# Response from Newark and Sherwood District Council as Planning Authority

A46 Newark Bypass

Inspectorate's reference number TR010065

**Viewpoint 25: View south from Great North Road (A616) representative of views for road users**

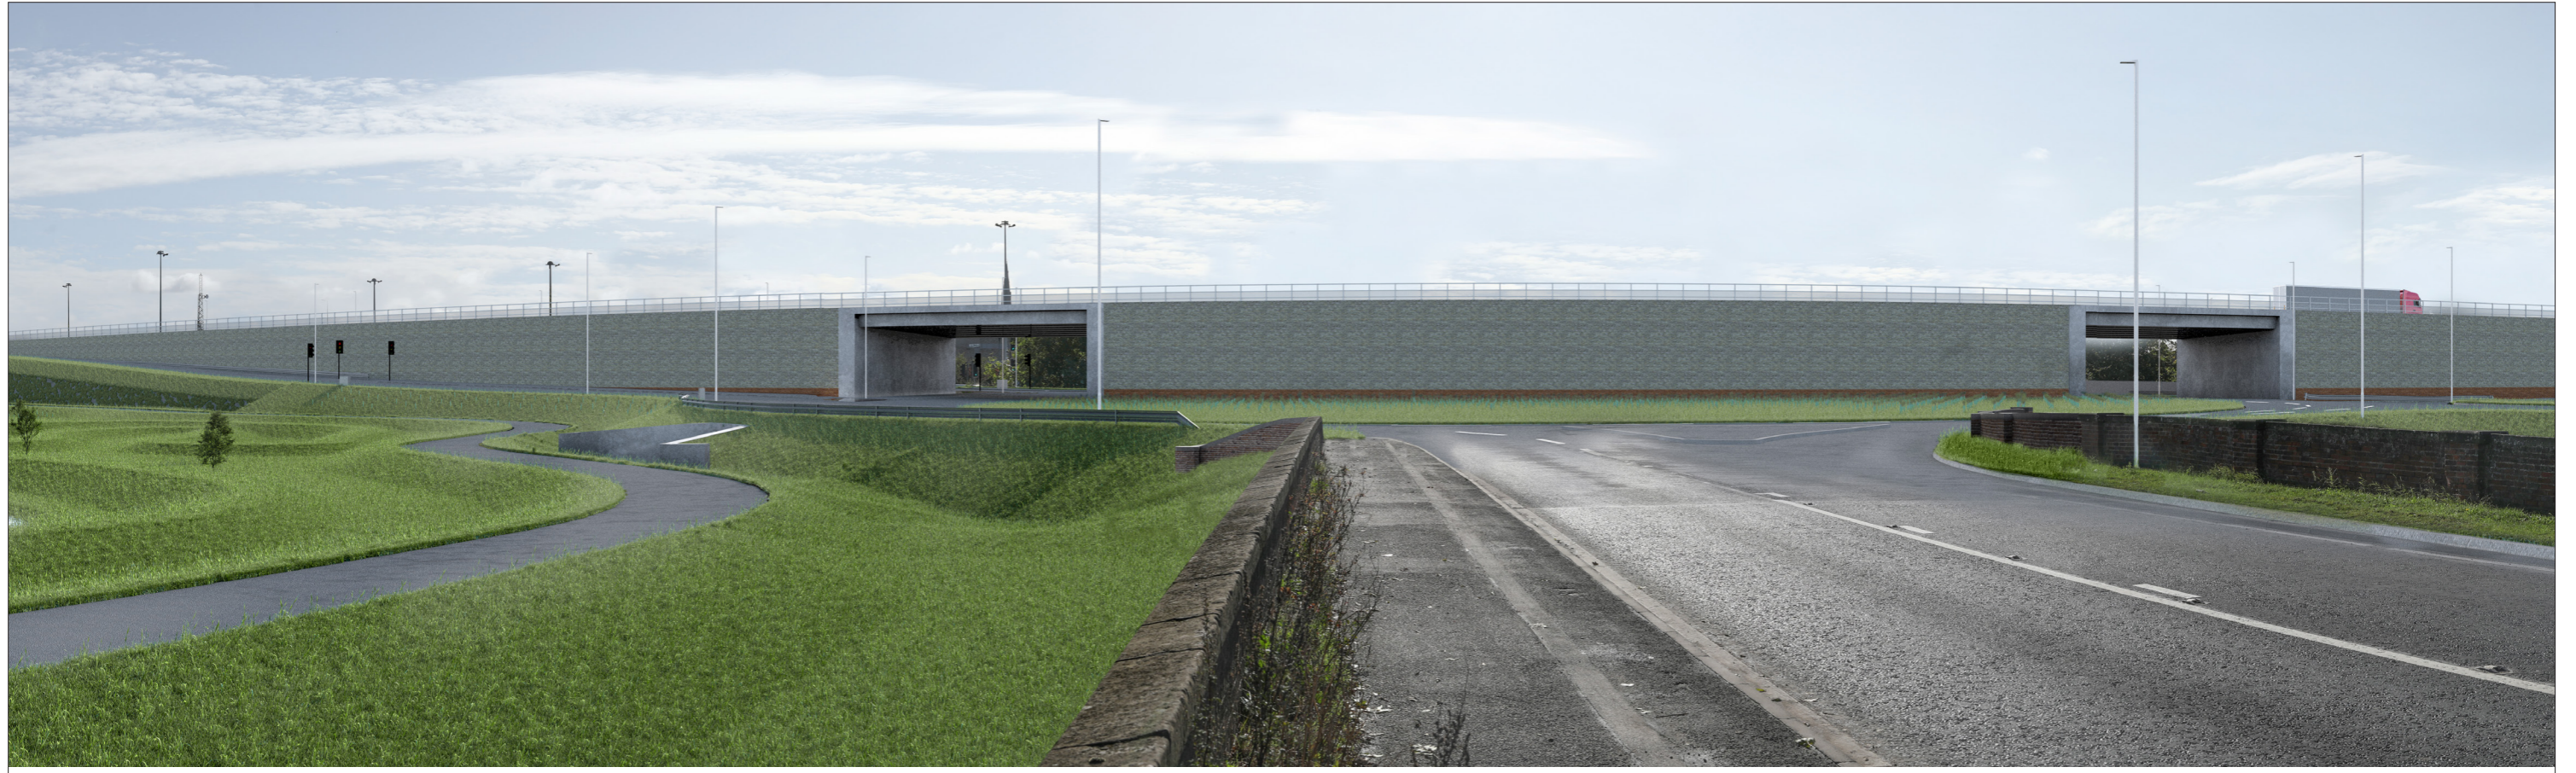
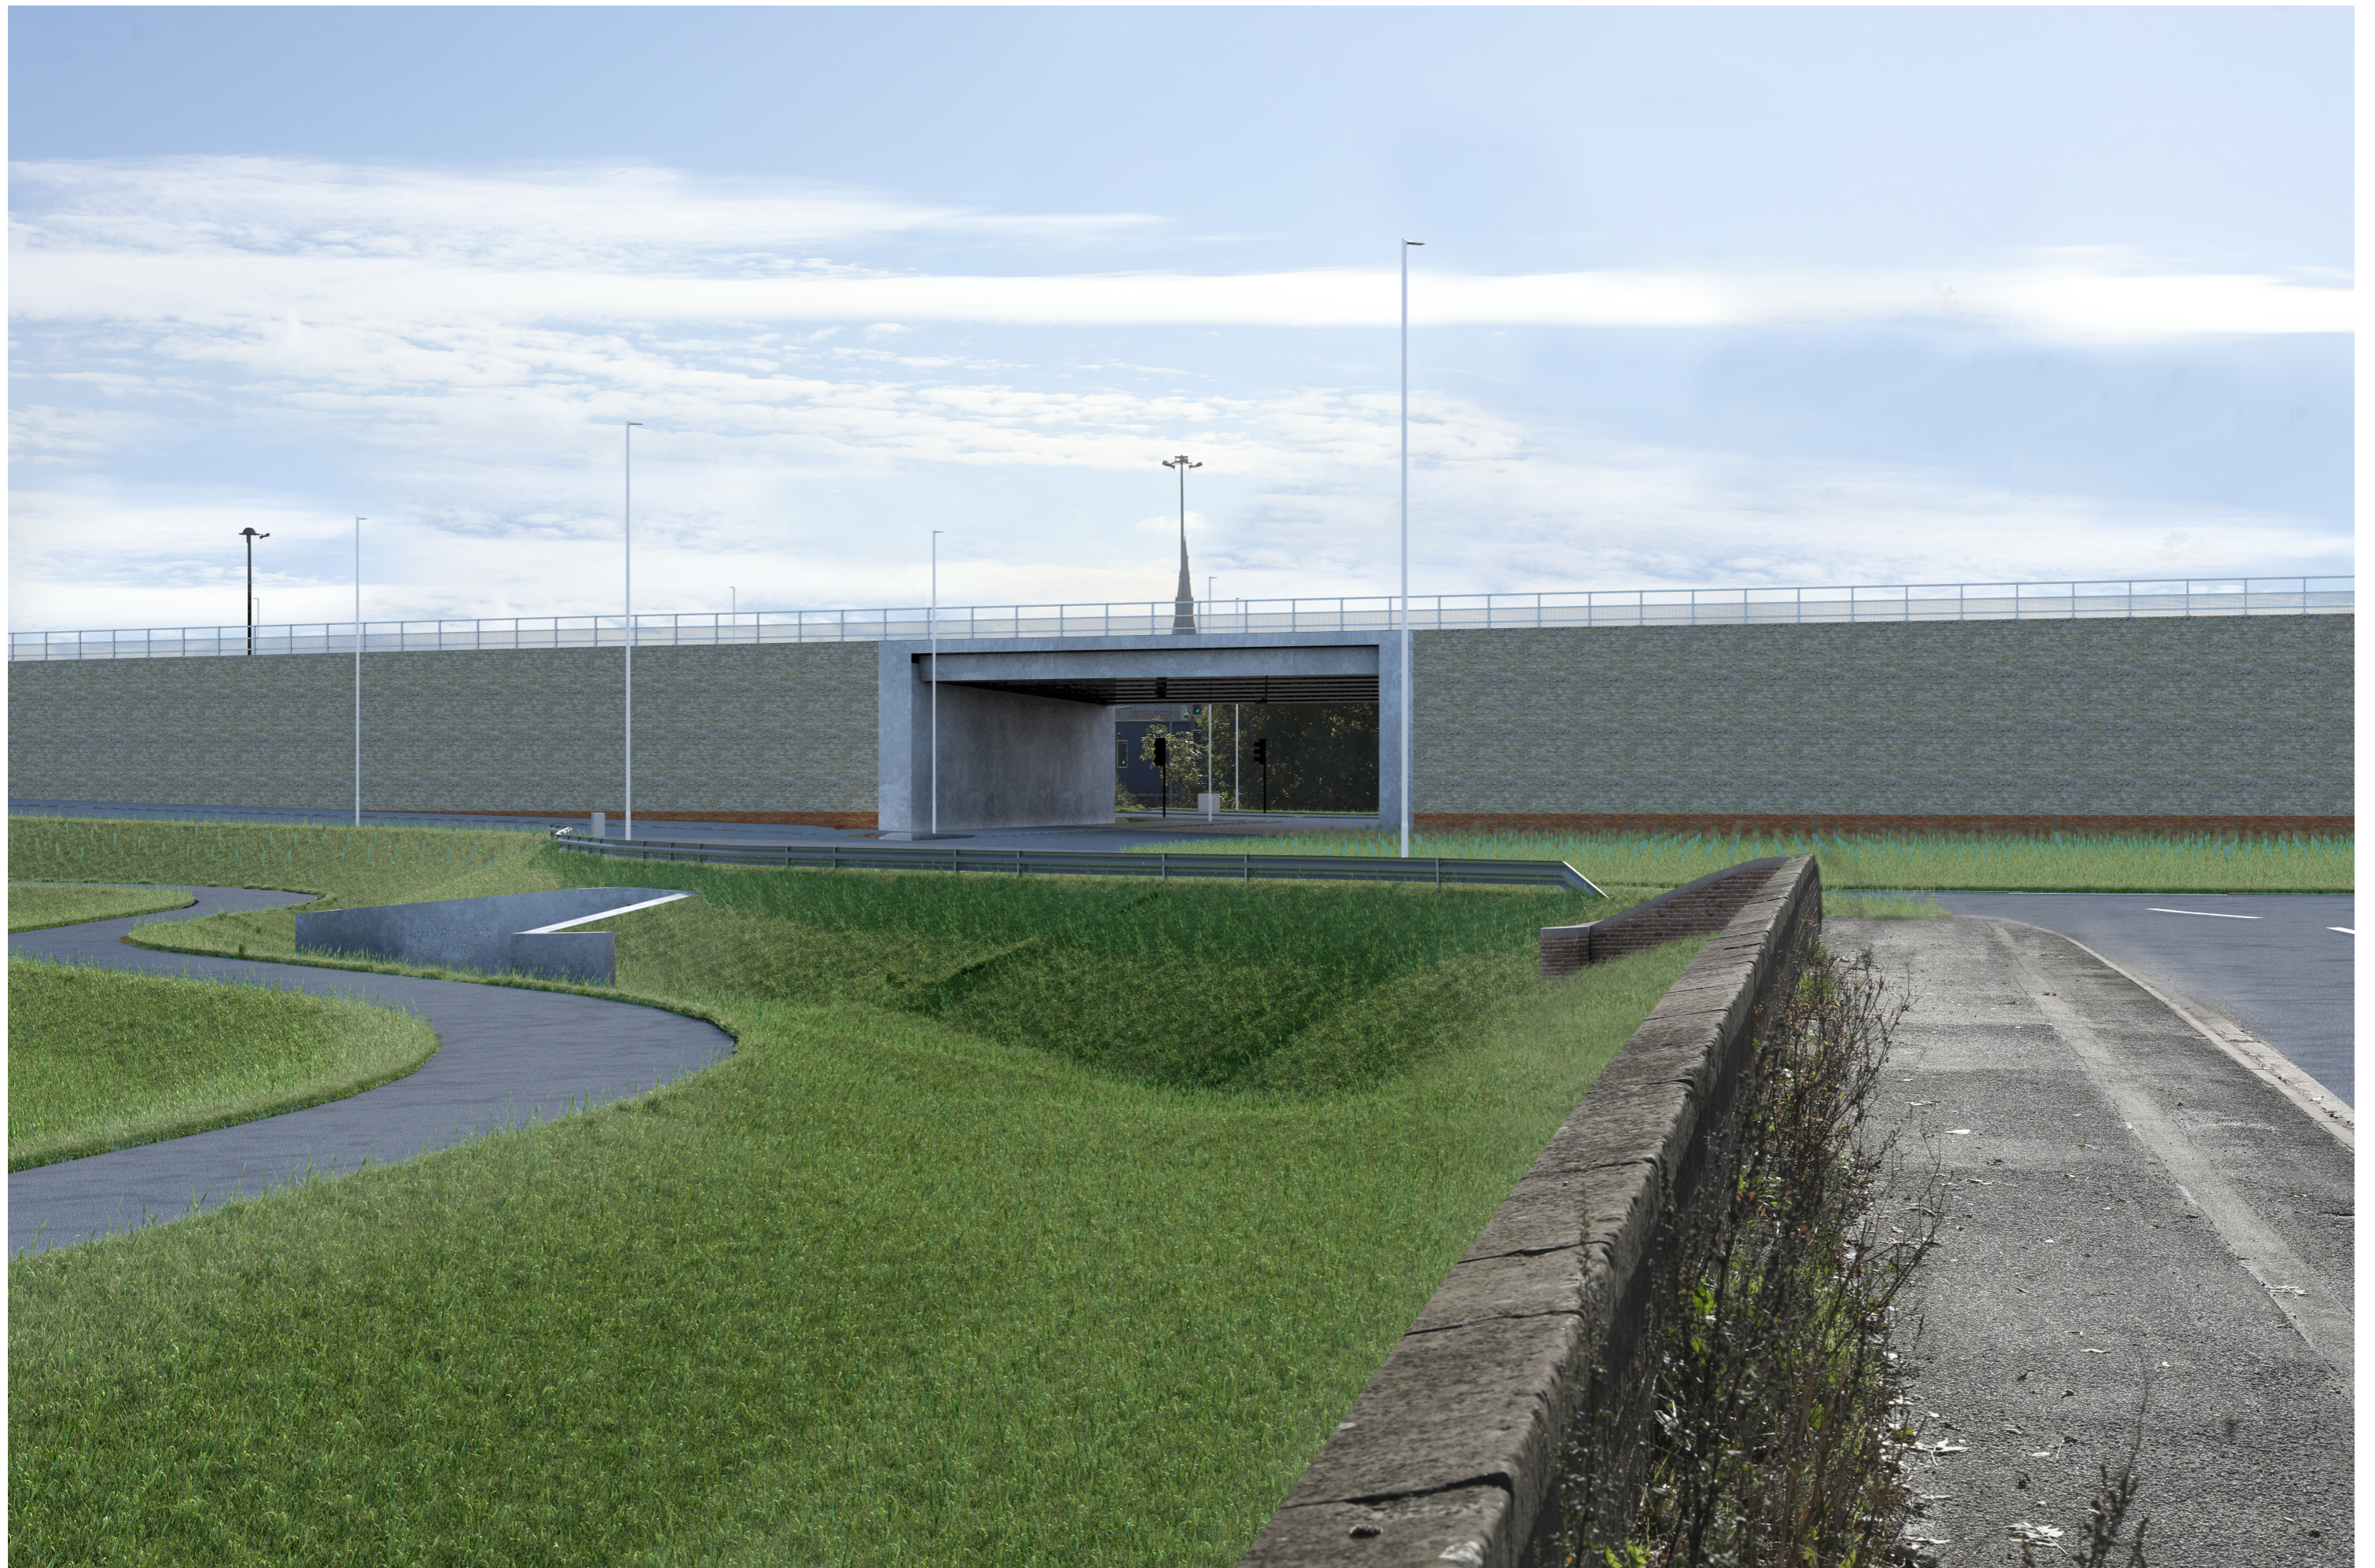
- Compliance with relevant legislation;
- Policy compliance and planning balance;
- Cultural Heritage – Built heritage - Although there is a visual receptor (no.25) in relation to Smeaton’s Arches, which is Grade II Listed, has not been identified as an important receptor. Due to the significance of the Smeaton arches, the significant historic approach along Great North Road into Newark, along with views of grade I listed St Marys Magdalene, this should be a ‘Key Visual Receptor and Photomontage’. This will allow for a full assessment on the potential impact of the engineering works will have on the setting of the listed building and historic route into Newark. In addition, it is considered that the visual receptors do not allow for a full assessment on potential impacts on Winthorpe Conservation Area. An additional visual receptor may be required or the existing (no. 41 & 43) may need to be wider than the 90 degrees shown. There are elevation plans for each bridge, however nothing showing the full length of the cattle market bridge from where it rises at Kelham Road to where it falls to the east. In addition, a full elevation of the bridge over the A1;
